Our Ref: PE/ARU/14/05/A

Date: 15th April 2014

Re: Kingley Gate Development, Phase 2 Courtwick Lane, Land South of Railway Station, Littlehampton.

Thank you for your correspondence of the 13th March 2014 advising me of an application for the approval of reserved matters for the 182 units of Phase 2 for the development at the above location, for which you seek advice from a crime prevention viewpoint.

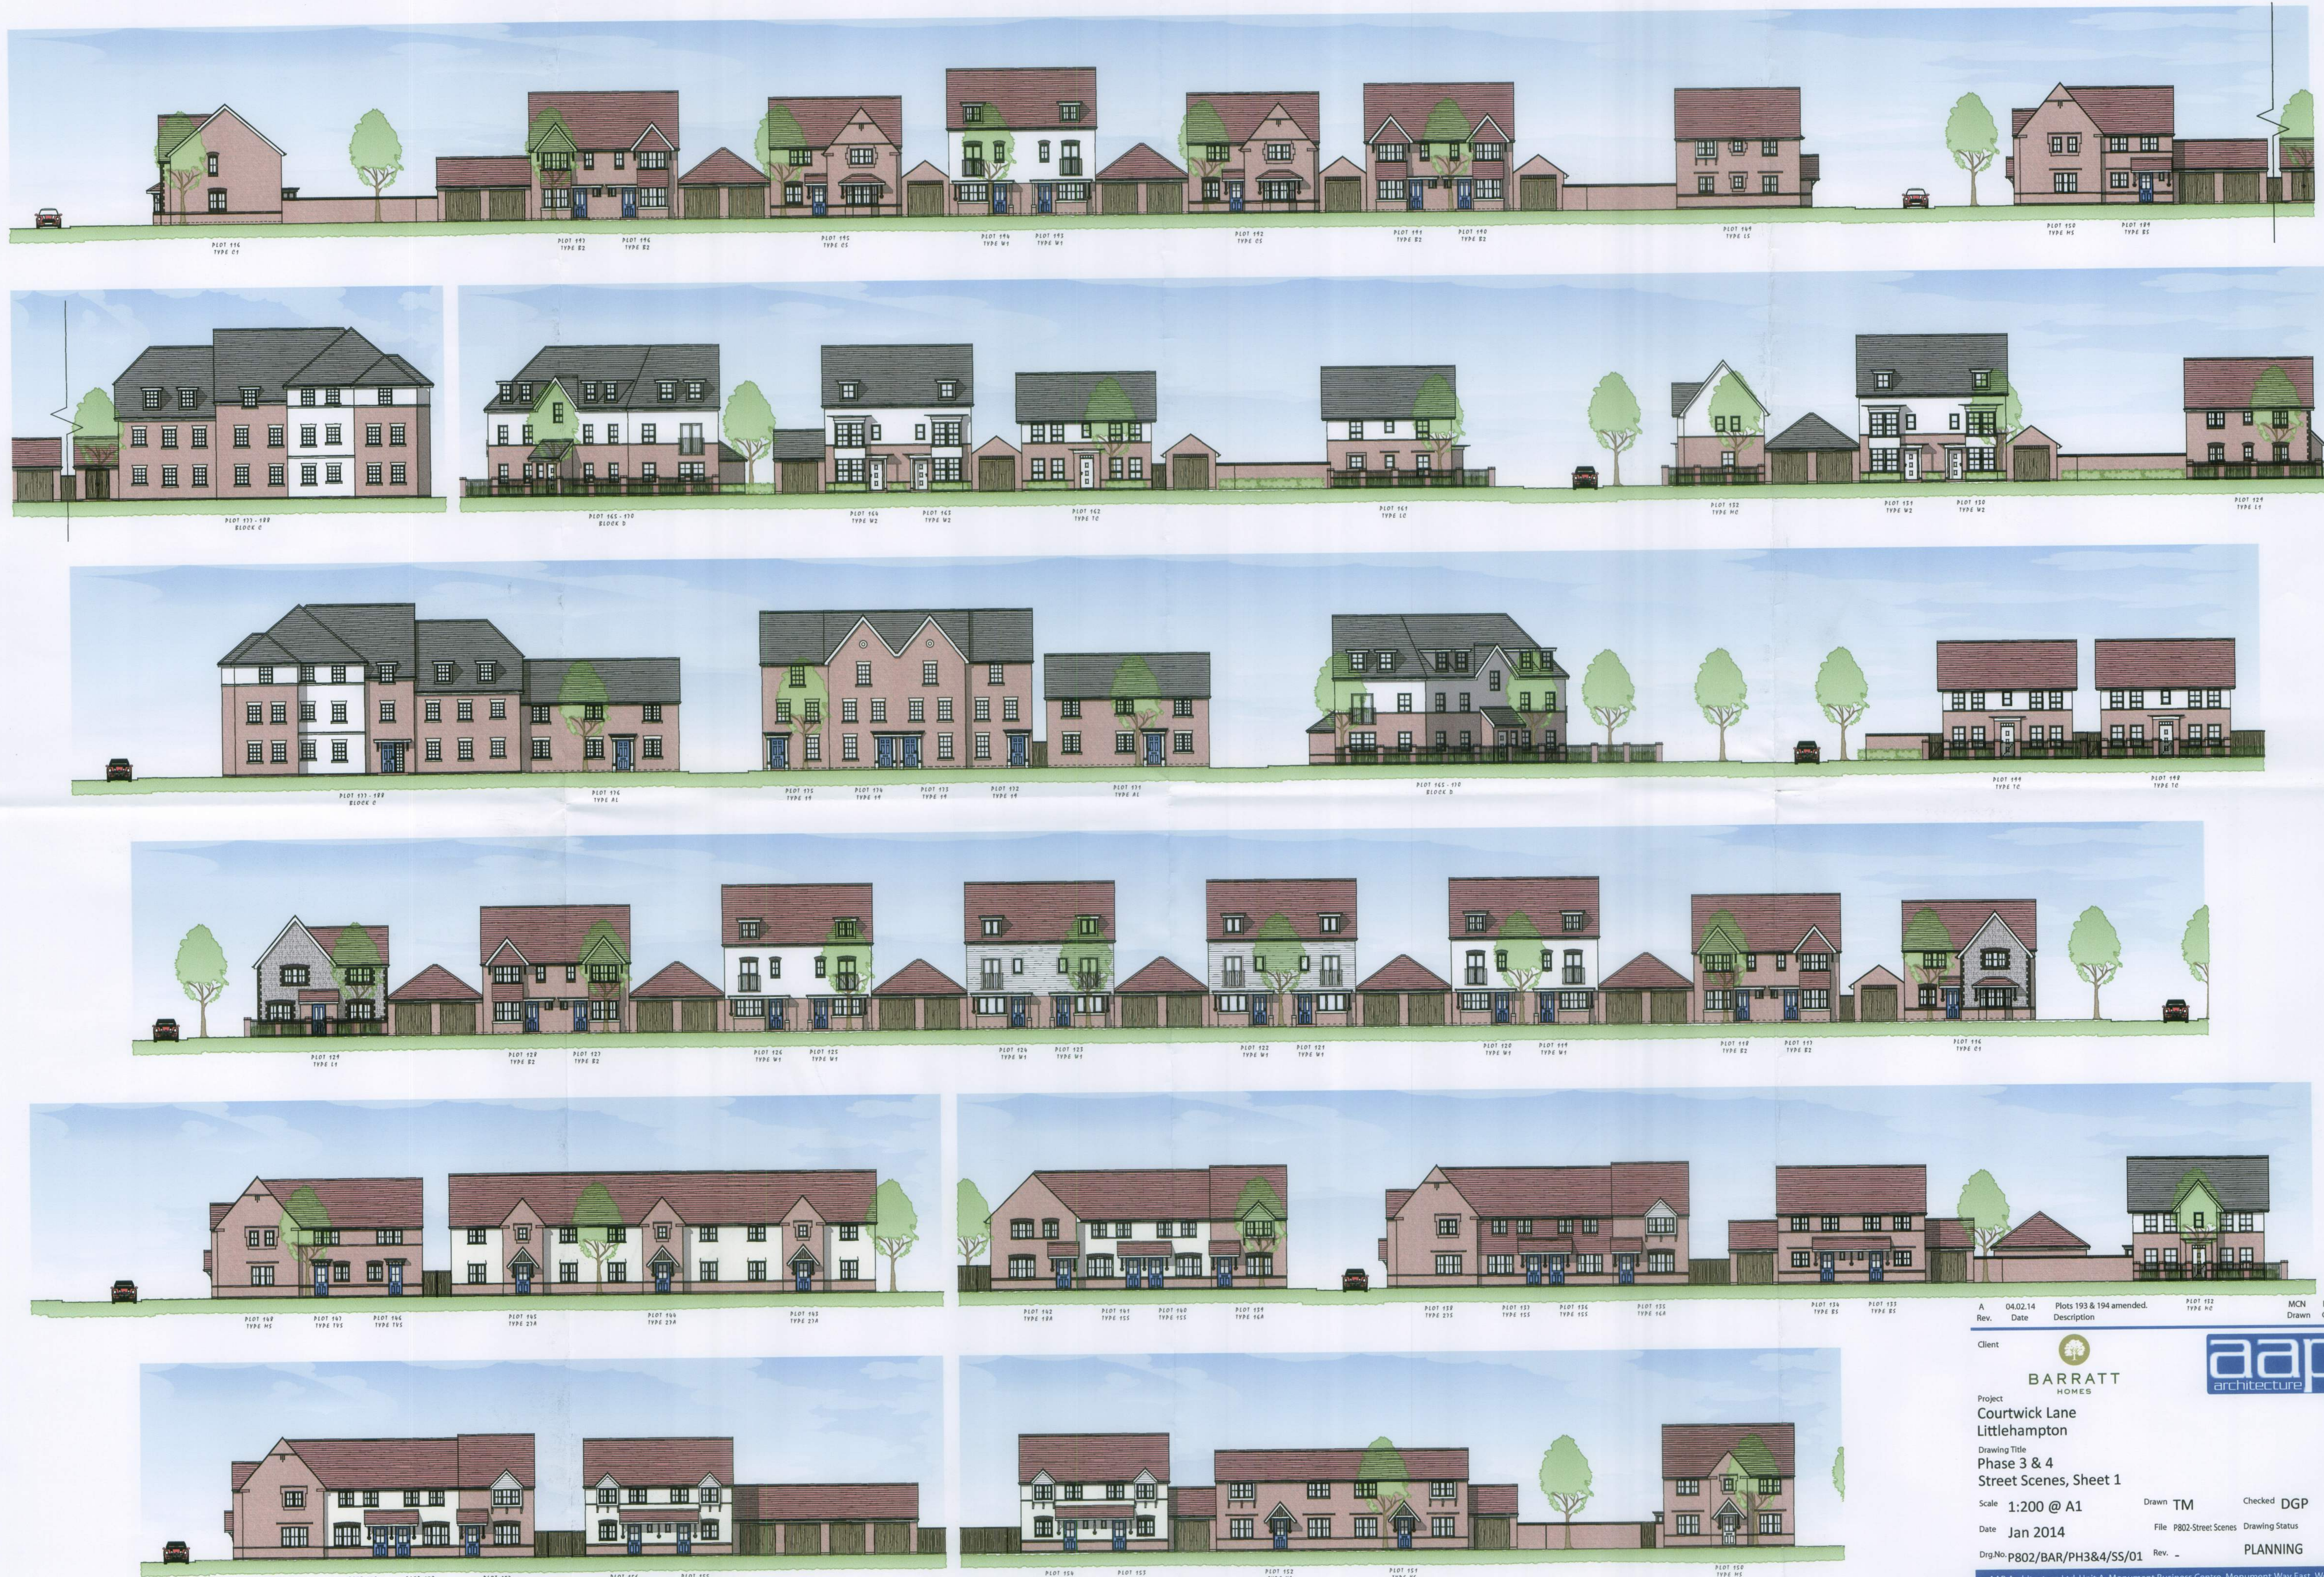
There are two rear parking courts where any cars parked would be unobserved along with a number of rear access pathways to the rear gardens. In both cases a combination of 1.5 metre high close board fencing topped with 300mm of trellis will provide observation into an other wise unobserved area.

Between plots 261 & 262, I note there is a proposed demarcation fence 1.8 metres high which separates the access to the rear gardens left and right. I feel that this unnecessary and will create a claustrophobic dark environment and could alienate neighbours. A solution would be to keep it gated at the front of the building and have a wider passage leading to the gates of the rear gardens of each property whilst still maintaining the garden fence height of 1.8 metres. Or alternatively have a small dividing fence of 1.2 metres high between the two dwellings, maintain levels of light and space promoting neighbour community relations.

The northern most LAP has very good surveillance over it; however the southern version is ringed on 3 side by parking bays which reduces the natural surveillance from the surrounding dwellings. Due to the close proximity of the parking bays and manoeuvring areas to the southernmost LAP, I recommend that this area has railings installed around it as is shown for the Northern most LAP.
